November 6, 2019

Ms. Lindsay Darden
El Paso County Planning and Community Development
2880 International Circle, Suite 110
Colorado Springs, CO 80910

RE: 5401 Fountain Valley School Road
Stealth Wireless Telecommunications Facility
(Verizon Wireless: CSP BIG JOHNSON)

Drawing Revisions (Rev. G, dated 9/26/19):

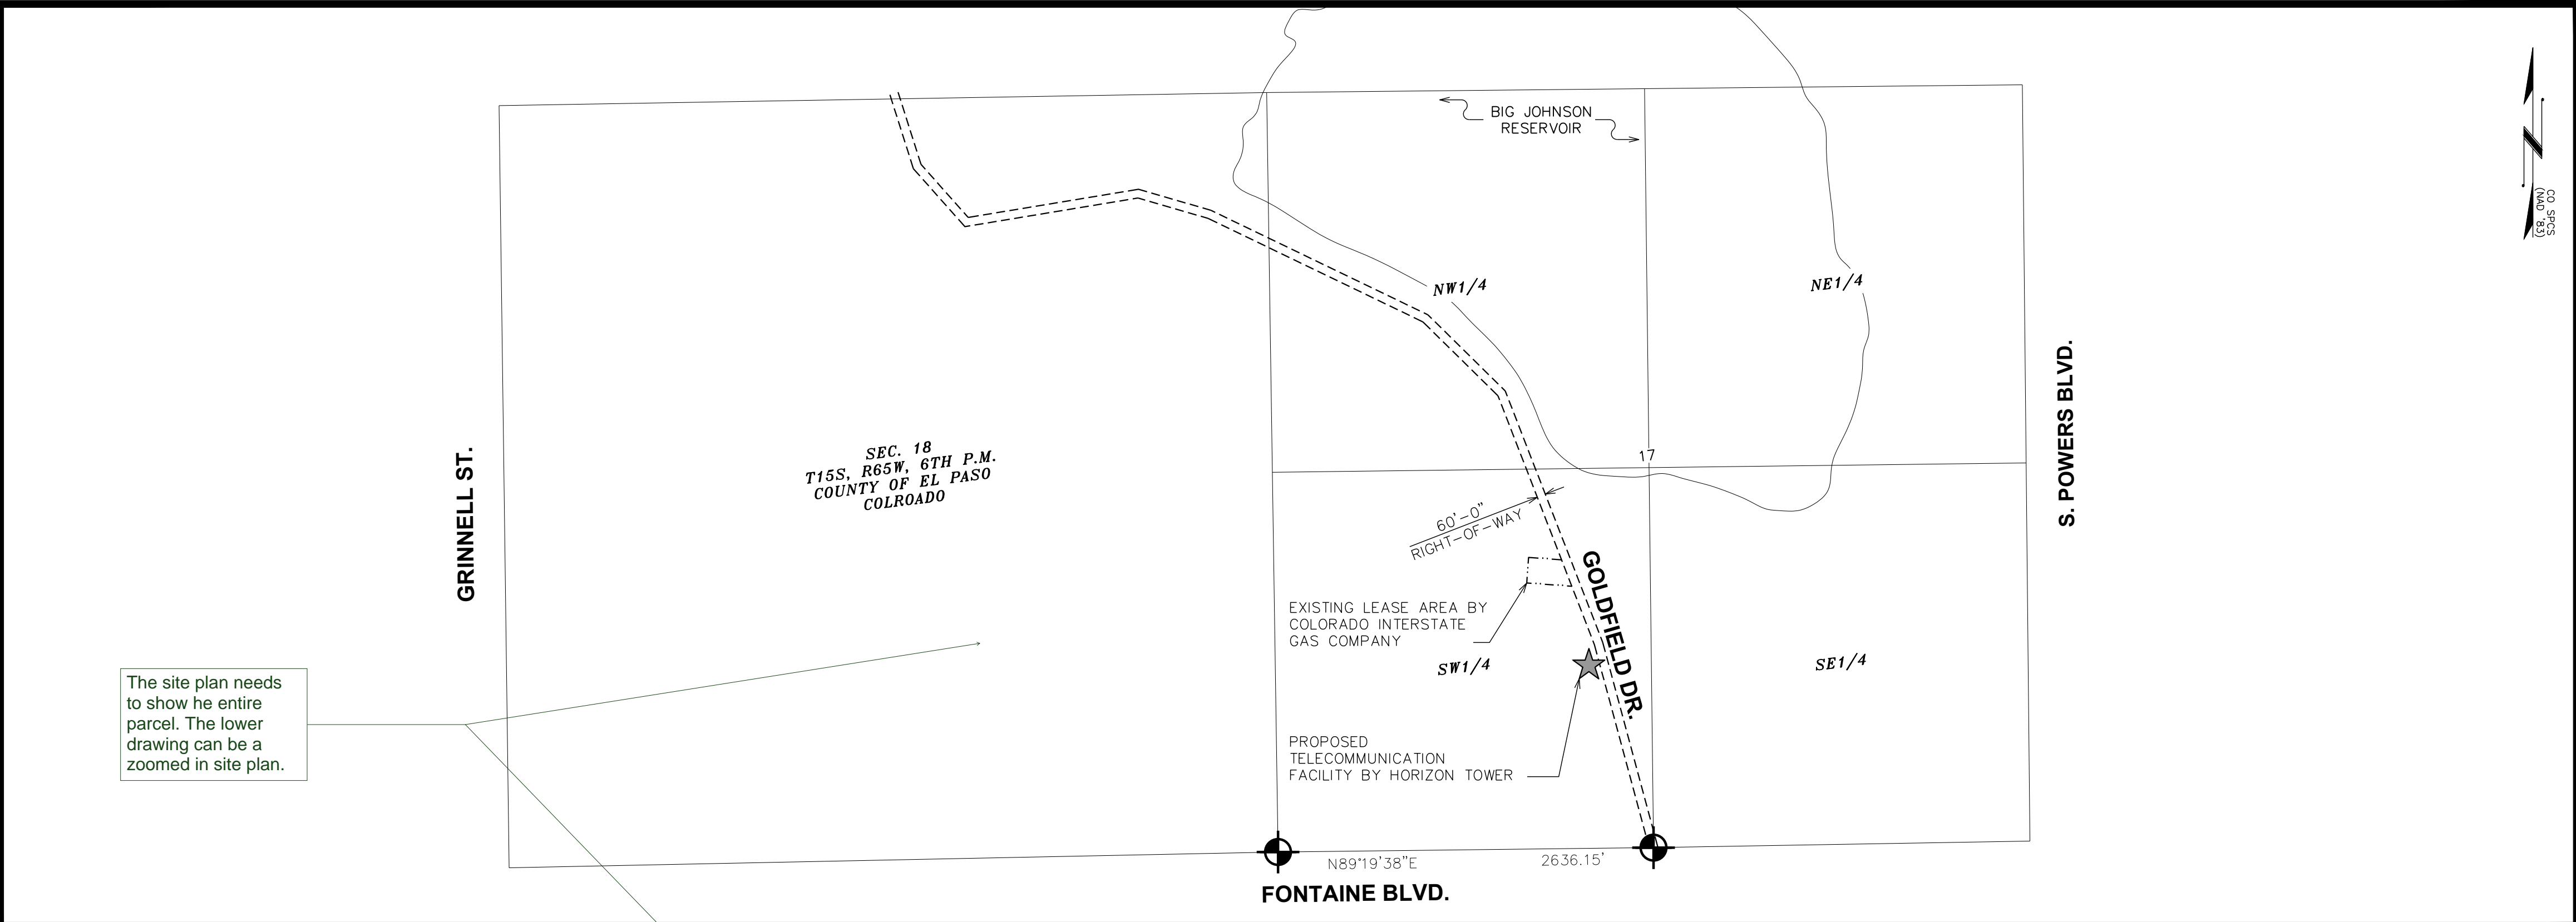
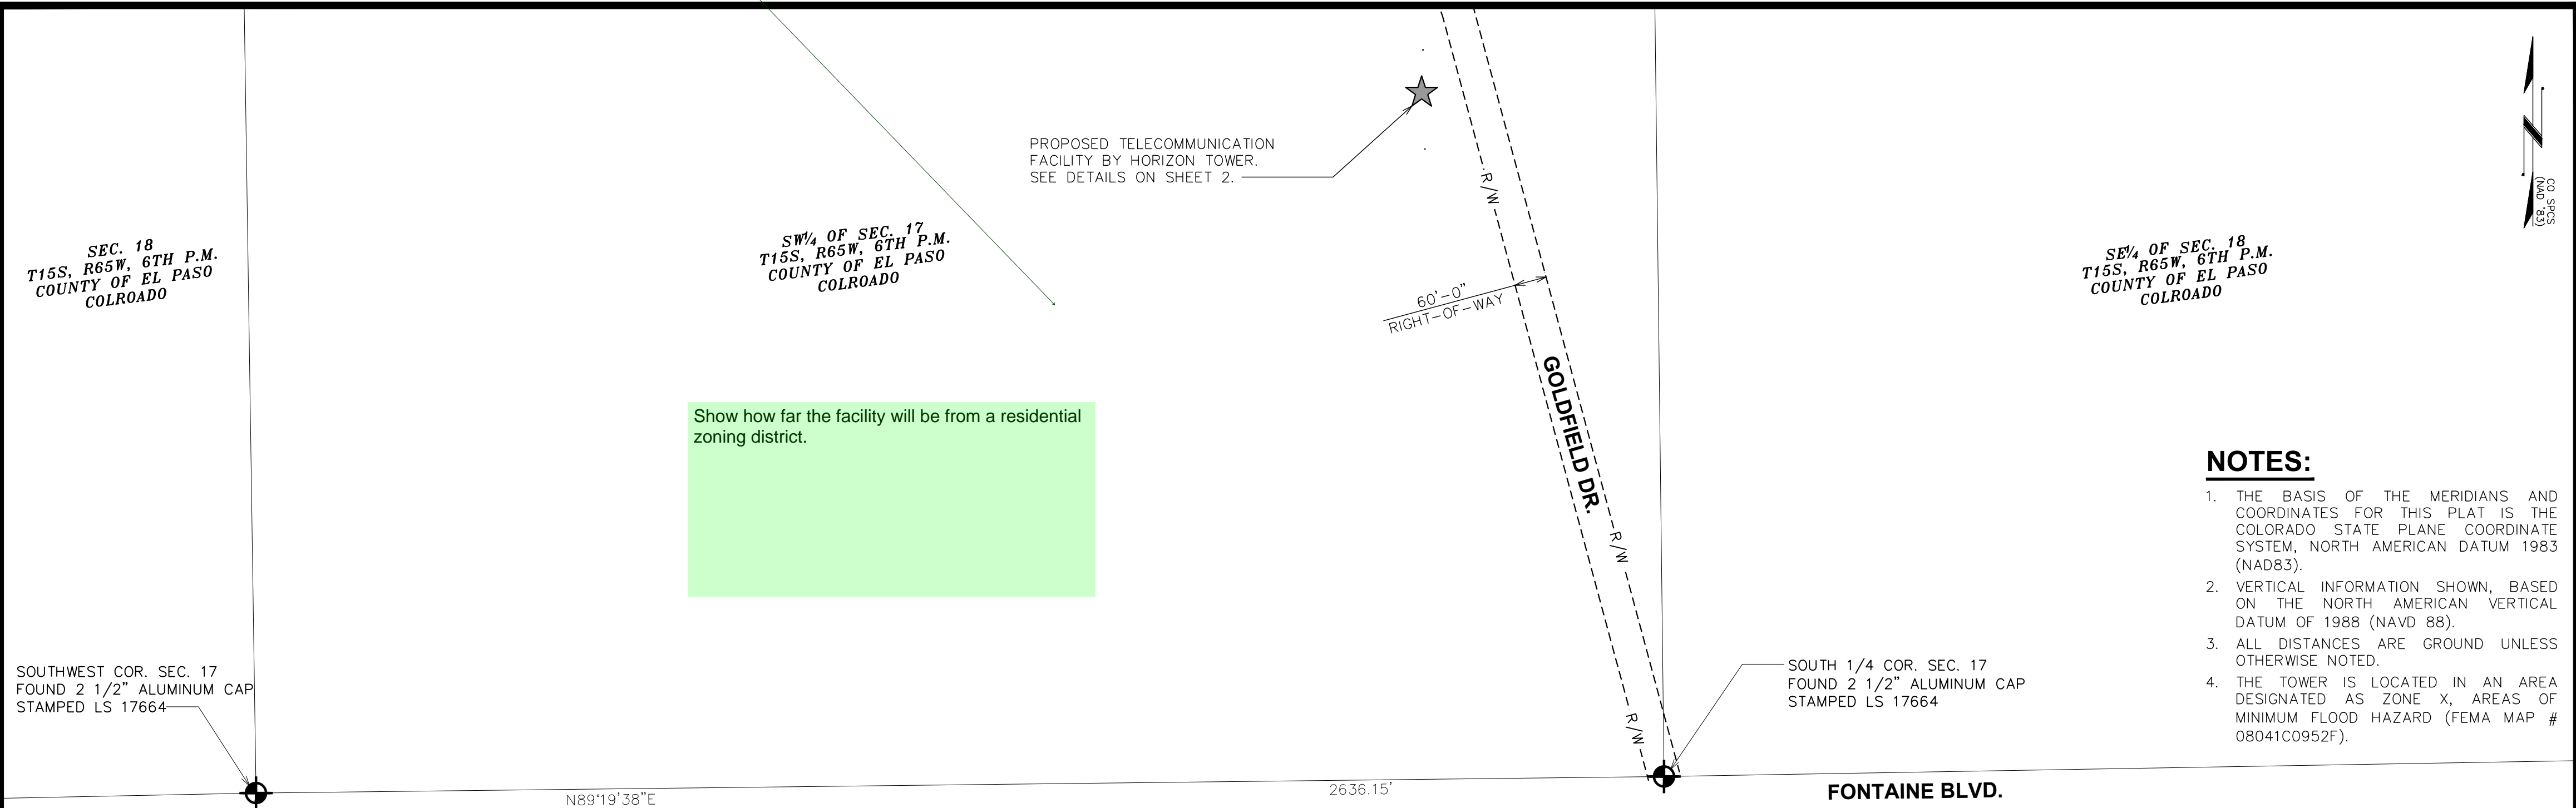
- PCD File Number: AL-19-021 added in the "Project Information" box on Sheet 1, and in Project Information in all page Title Blocks
- Note indicating tower lighting to be determined by FCC added to "Project Description" box on Sheet 1
- Dimension added to "Area Map" defining distance to residential parcel on Sheet 1
- Microwave call outs revised to say they cannot exceed 4' diameter on Sheets 3 & 4
- Fence Detail added into Page 2
- Acreage defined as 937 in "Project Information" box on Sheet 1
